REPORT UPDATE

Application No: BR/117/10/

LOCATION: 3 Spencer Street
Bognor Regis

PROPOSAL: Demolition of existing office building and erection of 9 no studio apartments over 3 storeys and associated external works

Drawing
Proposed Development -
Site Plan, Floor Plans + Elevations.

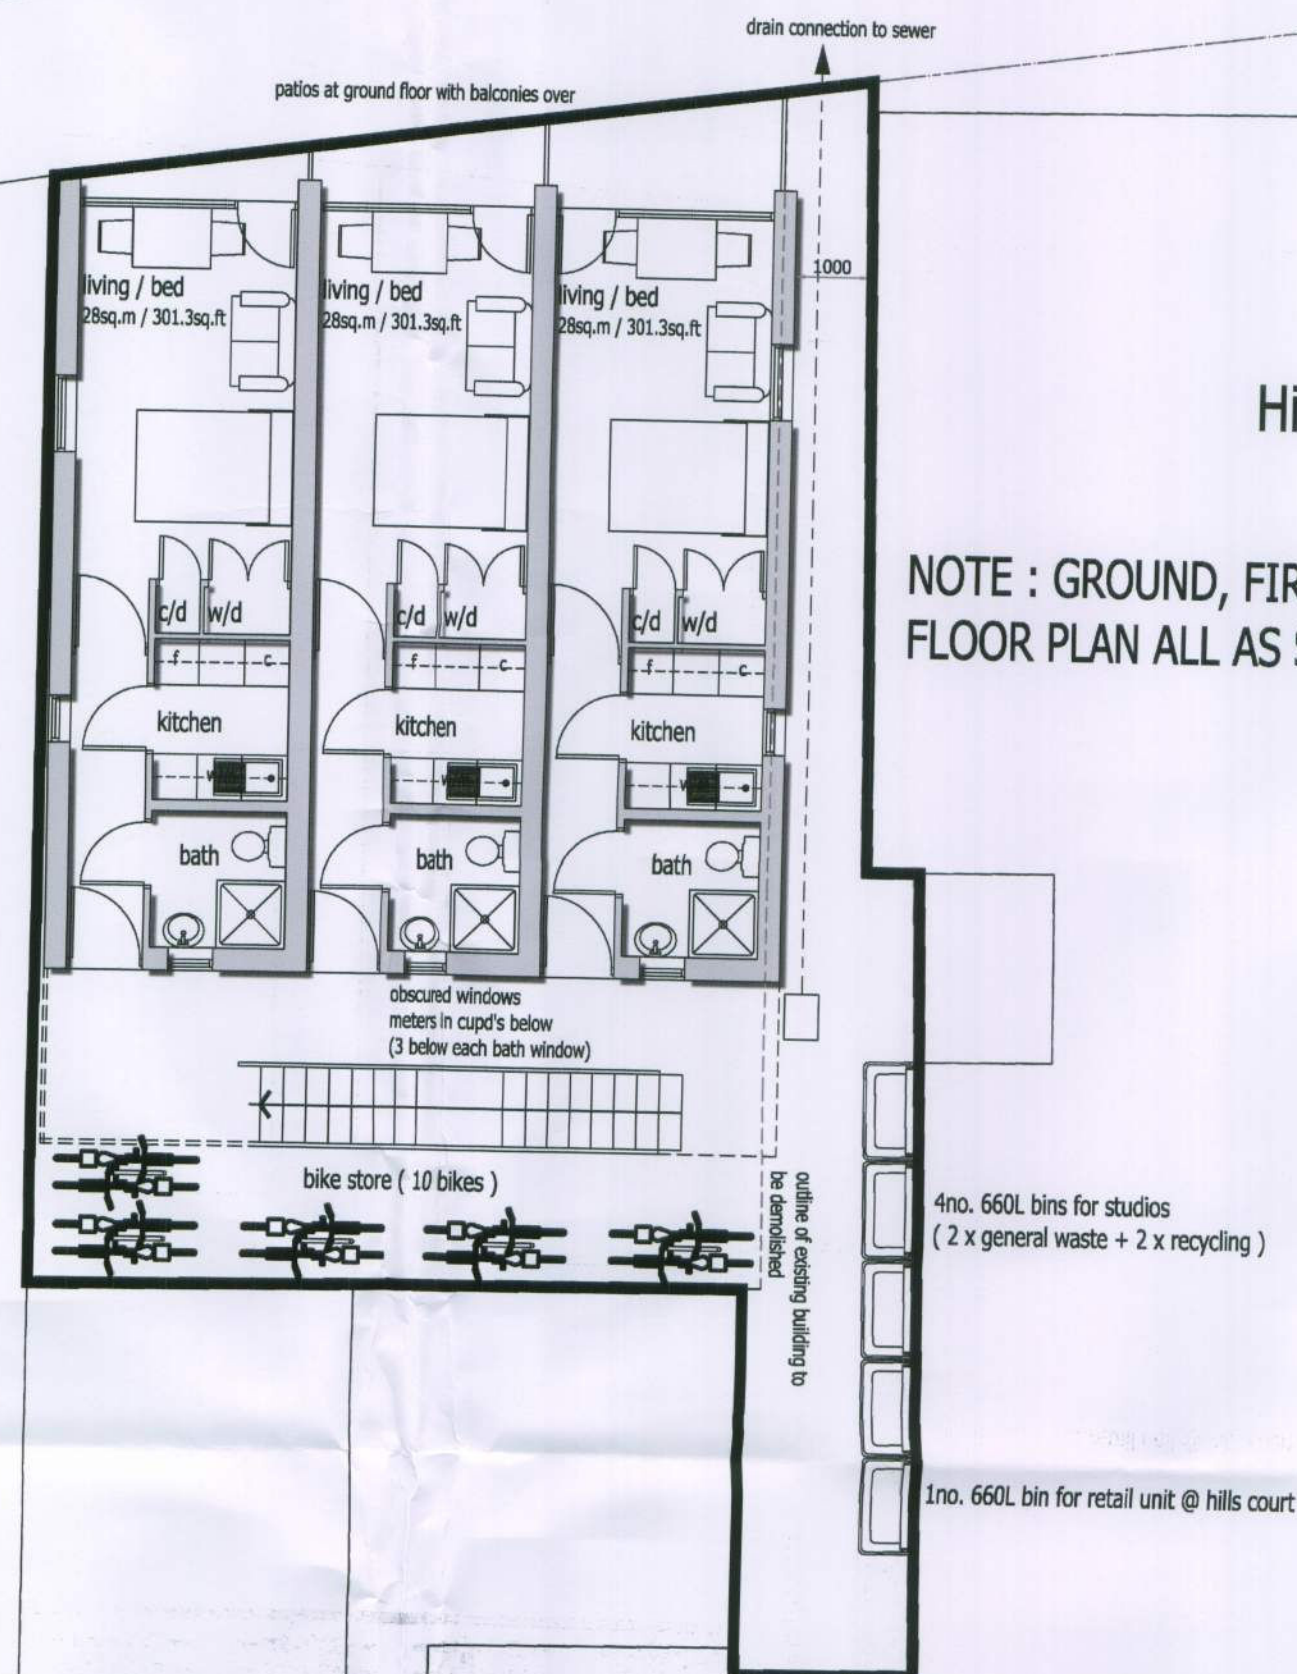
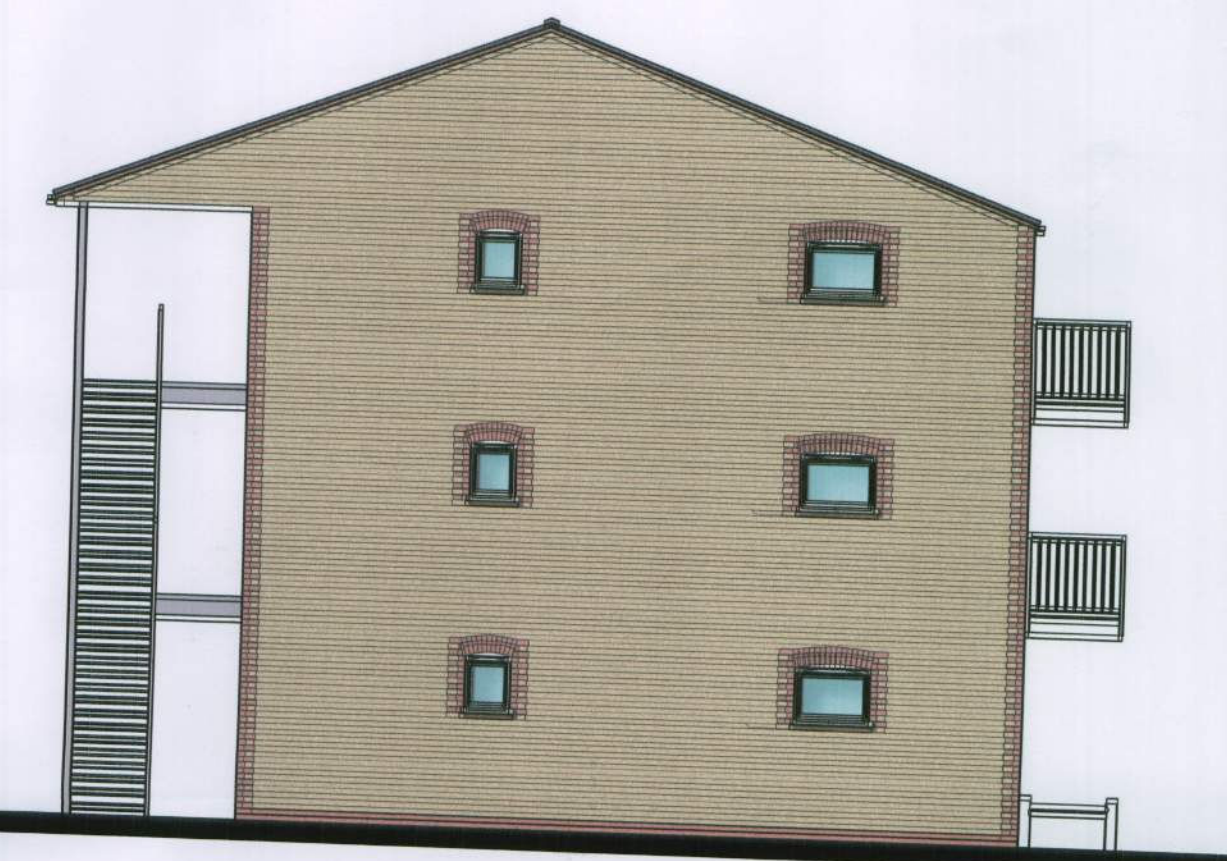
The three storey building is higher than the existing and is therefore overbearing and will create overshadowing of neighbour at the rear. The appearance is monolithic and out of keeping. There are windows and stairs which overlook property to the rear. Height should be restricted, balcony should be enclosed and staircase internalised. Removal of business premises for more flats is regrettable. Insufficient parking.

The main living rooms (studio flats) are at the front of the buildings with balcony or patio amenity areas of 1.3m wide and a 1.3m rear walkway to the external stairs. There are no residential properties directly opposite the site as it is a builders yard (Olby's). To the rear the design provides only bathroom windows which will be opaque glazed and the entrance doors open onto a entrance hall. The gap to the rear of the flats in London Road is a minimum of 8.7m, as there is no direct overlooking from principal windows, this is considered to be satisfactory. The side windows are high level to prevent any potential overlooking.

Noted. The height is in keeping with the adjacent developments with similar 2 storey development in London Road. There are no habitable windows overlooking. The staircase is the only means of access to the 1st and 2nd floor and are only for access. The site is in a town centre location and in accordance with the maximum parking standards.
